8 St Lucius's Close  
Farnley Tyas

Ref:- Applications 2021/93006, 2021/93007, 2021/92969  
Yew Tree Farm, Farnley Tyas

These applications are all for Yew Tree Farm which is in the centre of the Conservation Area of Farnley Tyas.

PROJECT TITLE YEW TREE FARM			
DRAWING TITLE THE VILLAGE SECTION			
SCALE 1:100	DRAWN JH	CHECKED JH	PROJECT REFERENCE ODS_20/294
PAPER SIZE A3	DWG NUMBER (72)003	DATE 25/3/21	REVISION /
CLIENT RADCLIFFE DEVELOPMENTS (FARNLEY)

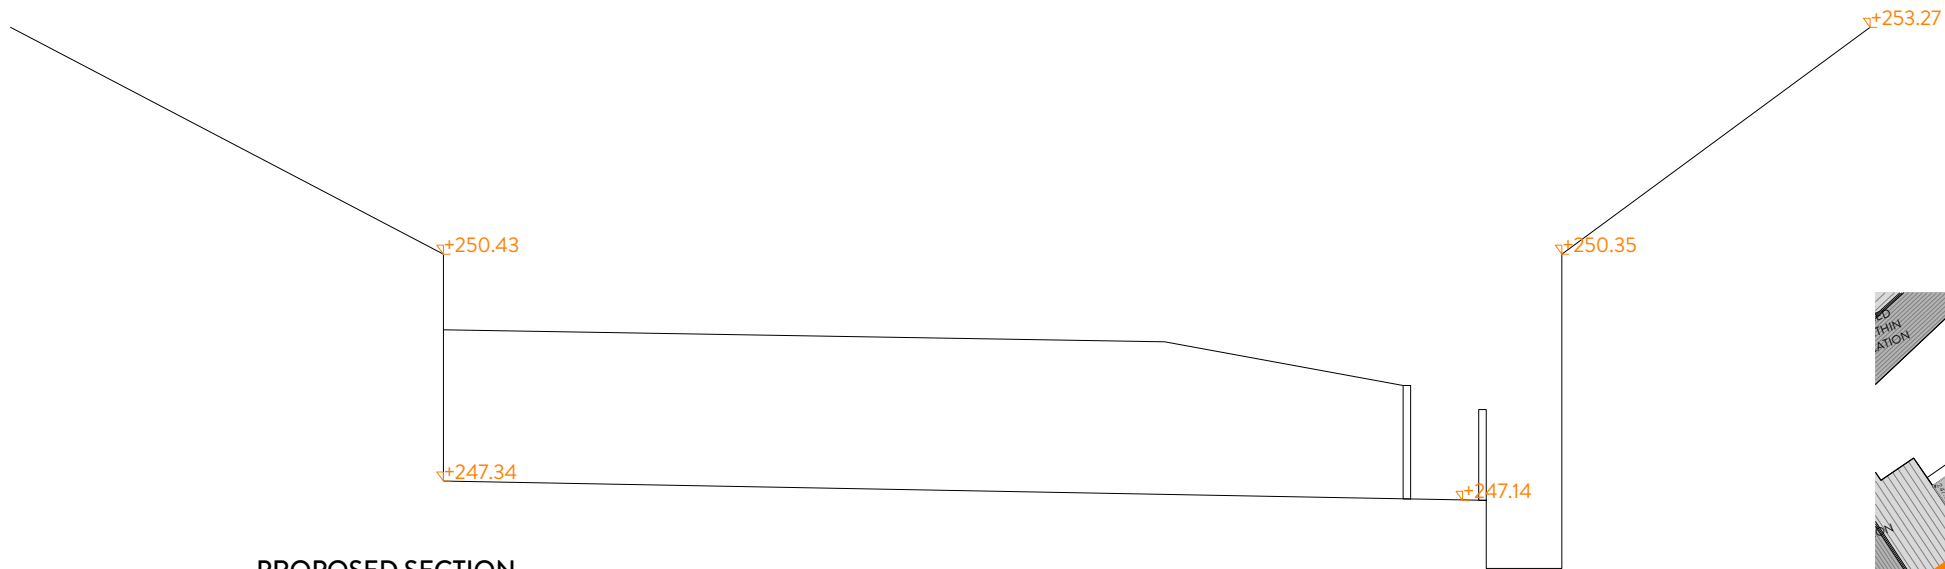
The applicant does not appear to provide adequate details, in the plans, of the

difference in height levels on this development, which are necessary in order for an informed decision to be made by Kirklees officers or Councillors on a Planning Committee.
